Chelmsford City Council

Relevant Representation to A12 Chelmsford – A120 Widening

VIEWPOINT 2: Representative view west from PRoW 213_45 on Paynes Lane, Boreham

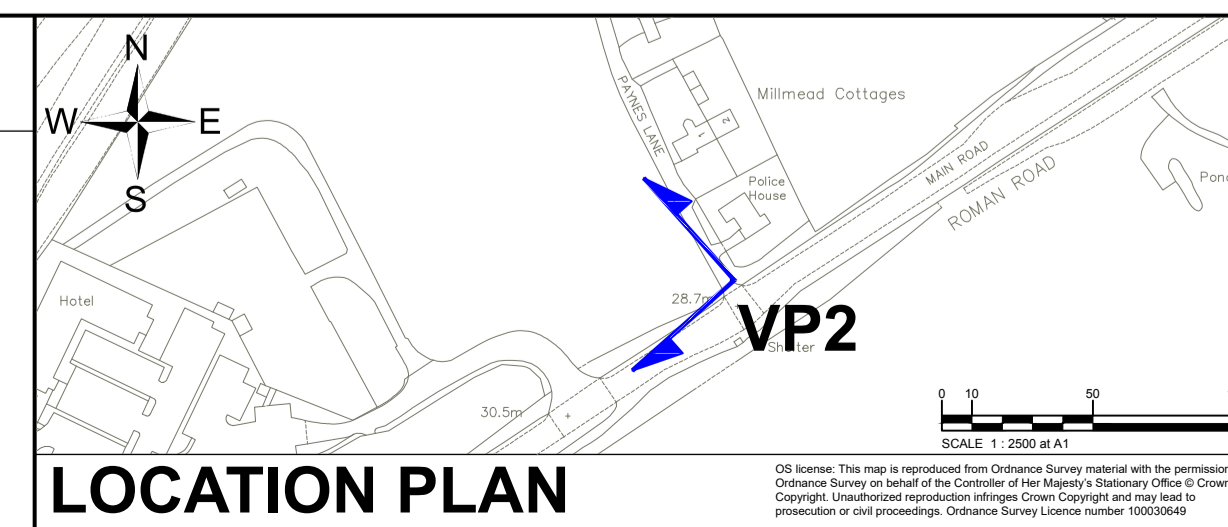
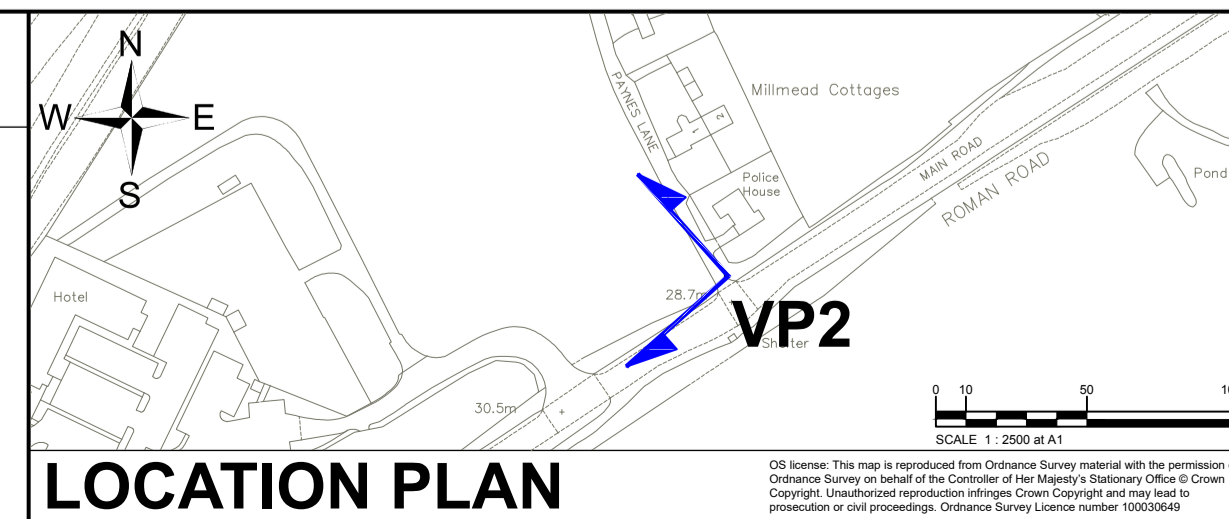
The proposed alterations to Junction 19 (Boreham) and the construction of the Paynes Lane bridge in themselves are not expected to harm or create unacceptable impact upon Boreham settlement and its residents. However, the closure of Junctions 20a and 20b to the north of Boreham at Hatfield Peverel and their replacement with a new junction 21 (Witham South Interchange), to provide access to the A12 northbound and southbound, is expected to impact upon Boreham settlement and its residents. Due to the closure of Junctions 20a and 20b and the construction of a new junction 21 to the north east of Hatfield Peverel, the proposal is likely to lead to an increase in trips along the B1137 (Main Road) and through Boreham.

However, the proposed design of the bridge is considered adequate, having a functional, rather than an aesthetic appearance, such that a design of a higher standard and distinctiveness is required to integrate the bridge with the wider Garden Community development.
